**Our ref:** HA/2022/124004/07-L01  
**Your ref:** M/16/22/PL  
**Date:** 07 March 2023

**FURTHER MODELLING INFORMATION: RE-CONSULTATION - LAYING OUT OF AN 18 HOLE 72 PAR GOLF COURSE, A 9 HOLE GOLF COURSE, PRACTICE GREENS AND A DRIVING RANGE INCLUDING A BUGGY COMPOUND; THE FORMATION OF A NEW ACCESS ONTO THE A259; CONSTRUCTION OF A CLUB HOUSE WITH ASSOCIATED GOLF CLUB FACILITIES; THE CONSTRUCTION OF A MAINTENANCE BUILDING AND EXTERNAL AREA OF HARDSTANDING; THE LAYING OF PARKING, NEW ROADS AND PATHS; NEW LANDSCAPE PLANTING; SURFACE WATER DRAINAGE BASINS AND WATER STORAGE RESEVOIRS; AND OTHER EARTH WORKS AND INFRASTRUCTURE. THIS APPLICATION ALSO LIES WITHIN THE PARISHES OF CLIMPING AND YAPTON, IS A DEPARTURE FROM THE DEVELOPMENT PLAN AND AFFECTS A PUBLIC RIGHT OF WAY. THIS APPLICATION IS SUBJECT TO AN ENVIRONMENTAL STATEMENT. LAND SOUTH OF GREVATTS LANE/A259 CLIMPING.**

Following a review of the technical note dated 7<sup>th</sup> February 2023 we are now able to remove our objection. The proposed development will only meet the National Planning Policy Framework's requirements in relation to flood risk if the following planning condition is included.

Project	BOGNOR REGIS GOLF CLUB		
Client	HALLAM LAND MANAGEMENT		
Drawing	GRADING PLAN		
Scale	1:2500@A1	Date	04.02.22
Orig. No.	1352.405.01	Design	GD
		Drawn	TK
		Checked	-

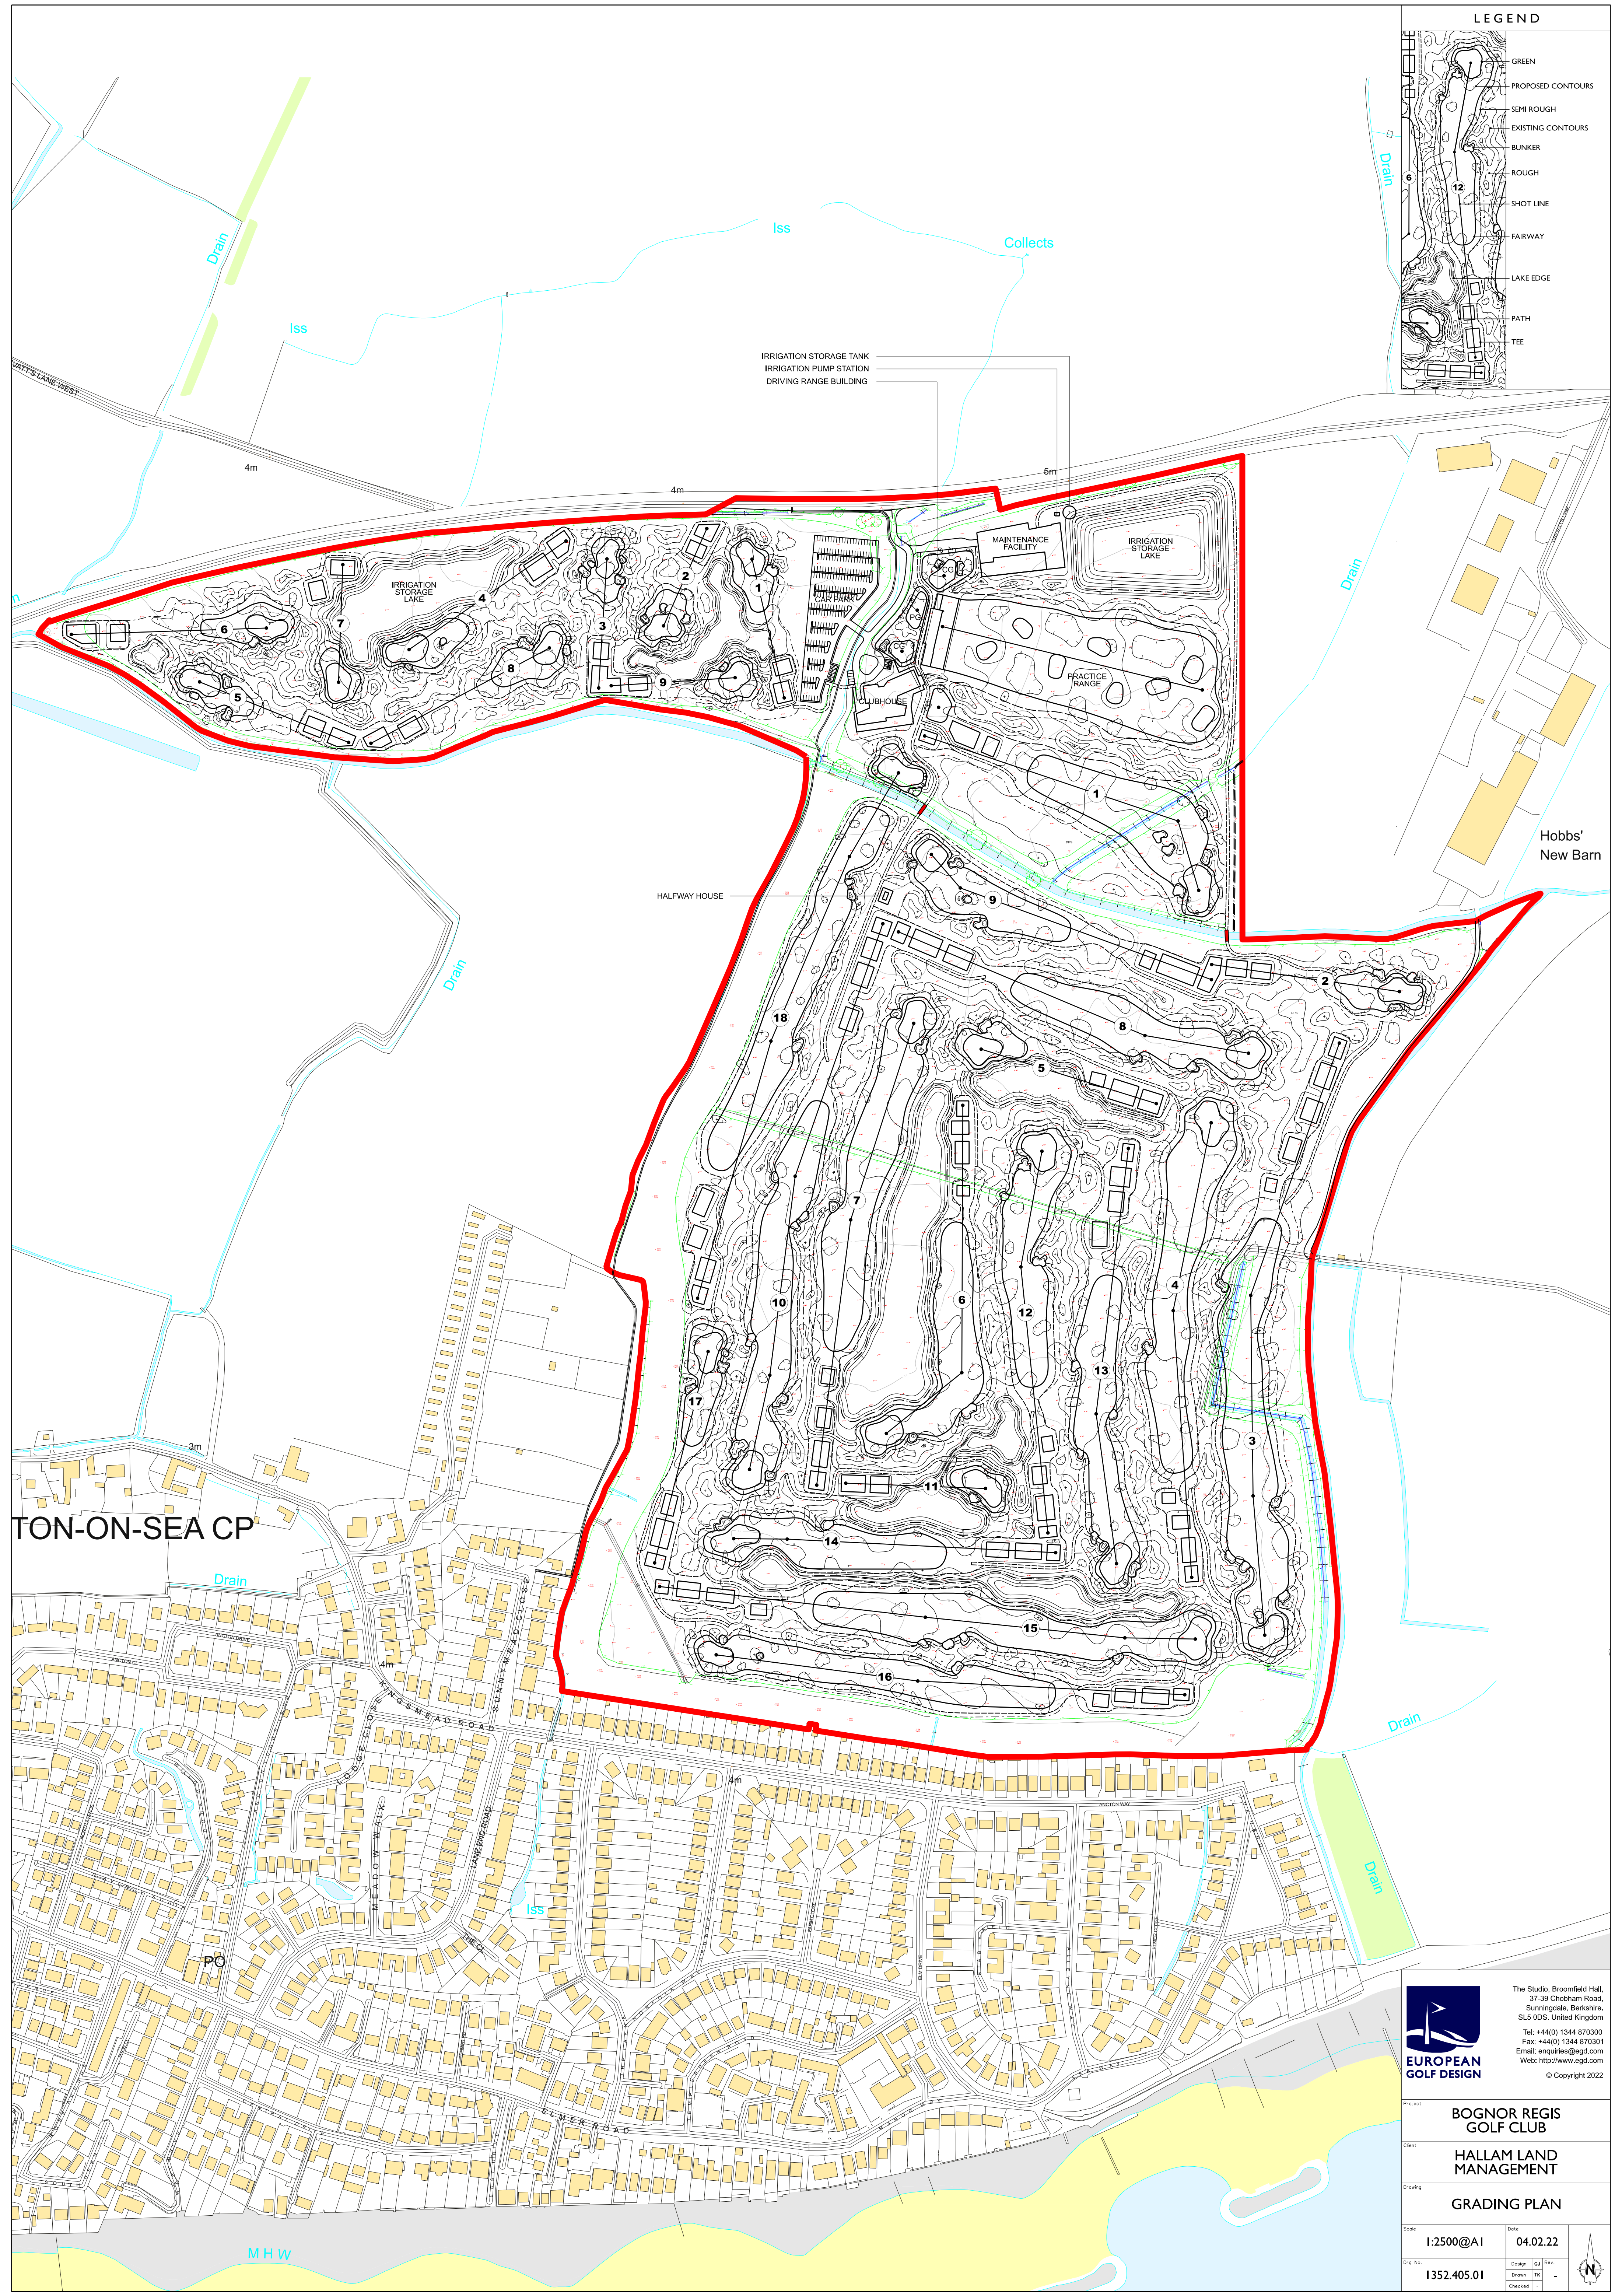
- Post development ground levels must match those provided in drawing 'Grading Plan – 04.02.22' found in the supplied hydraulic model report ref 70088068-HMR1.
